TOWN AND COUNTRY PLANNING ACT 1990 FULL

Reference: H12-0949-25 **Date of Decision:** 2nd December 2025
Applicant: South Lincs Methodist Church
22 Barrington Gate
Holbeach
Spalding
Lincolnshire
PE12 7LB
Location: Lutton Marsh Methodist Church Guys Head Road Lutton Marsh Spalding
Description: Change of Use, Conversion & Extension to Create a Single Dwelling

Job Ref.	4547-24	Drawing No.	02C
Date	APRIL 2025	Drawn	SLB

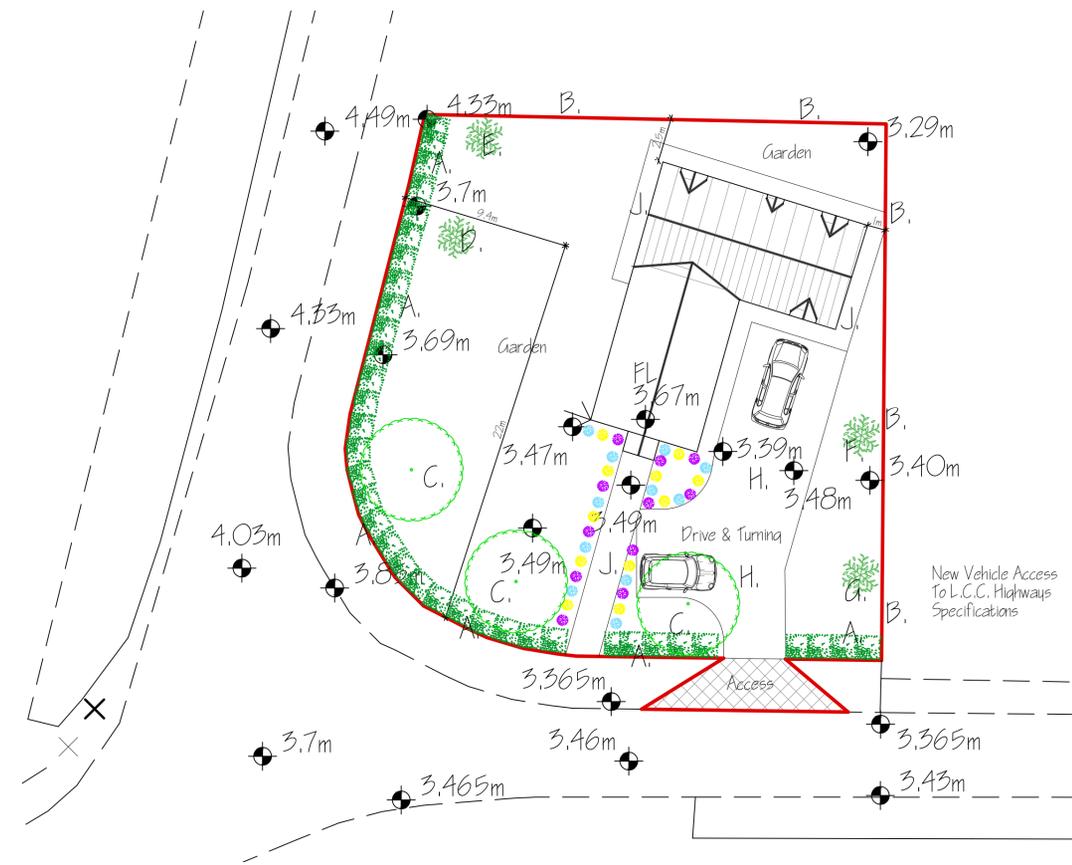
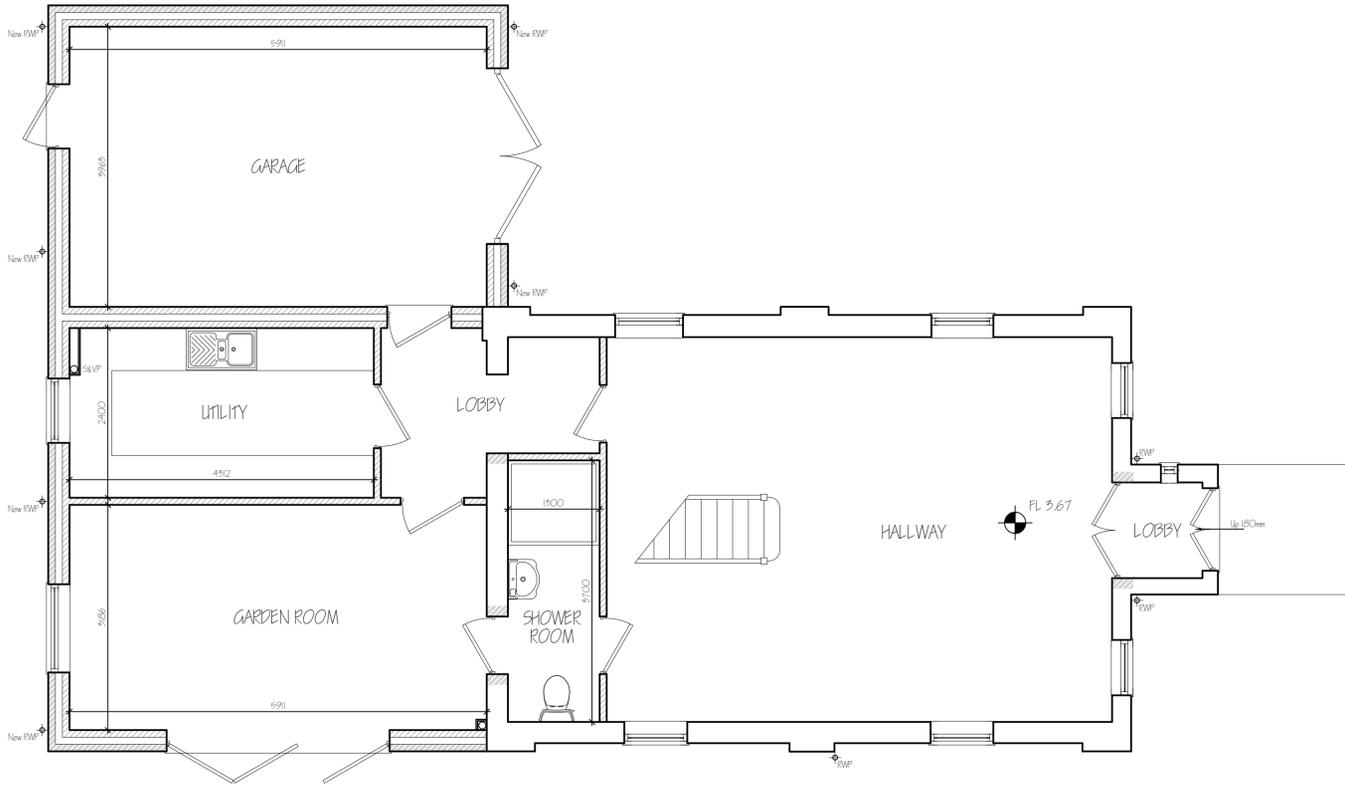
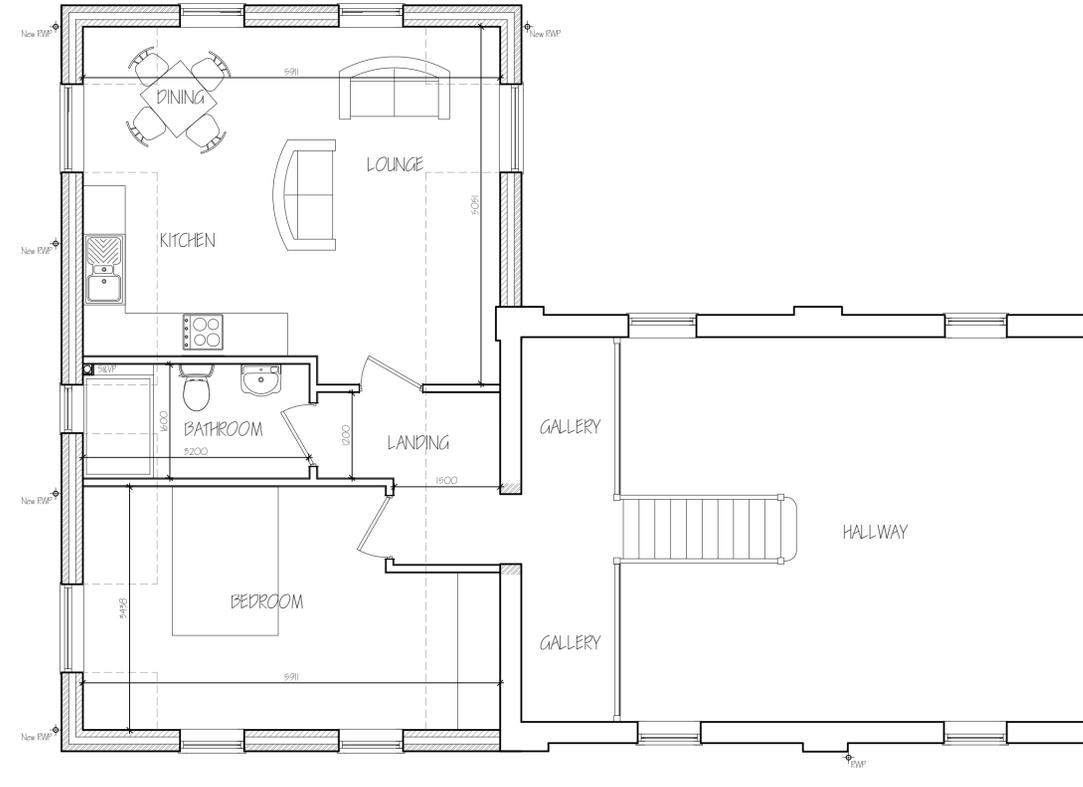
The extension is proposed to project from the rear elevation by 6500mm and would extend 4200mm from the side; whilst having a total length of approximately 10500mm. The scale of the extension, when considering the rear and eastern projections, are similar to that of the previously refused scheme on site, with minimal reduction or amendment to the overall size (with the exception of the western projection) to overcome the previous concerns. Whilst the proposed height has been lowered, the extension would still fail to offer a subservient or subordinate addition in relation to the existing built form of the church.

The height, coupled with the mass and bulk of the extension proposed, would create a large and overwhelming feature to the rear of the modest church and would introduce a detrimental addition, that would be harmful to the existing design and built form, which comprises historic value itself. The design conflicts with the design policies outlined above and would introduce a harmful addition to the area.

Furthermore, due to the historic value of the Methodist Church, the host building is considered to constitute a non-designated heritage asset. In this regard, the proposal would fundamentally alter the character of the building, and is of such a scale as to create a resultant form that would almost entirely 'crowd out' appreciation of the original building. The scheme neither conserves nor enhances the non-designated heritage asset or its setting, which conflicts with Paragraph 216 of the National Planning Policy Framework (December 2024).
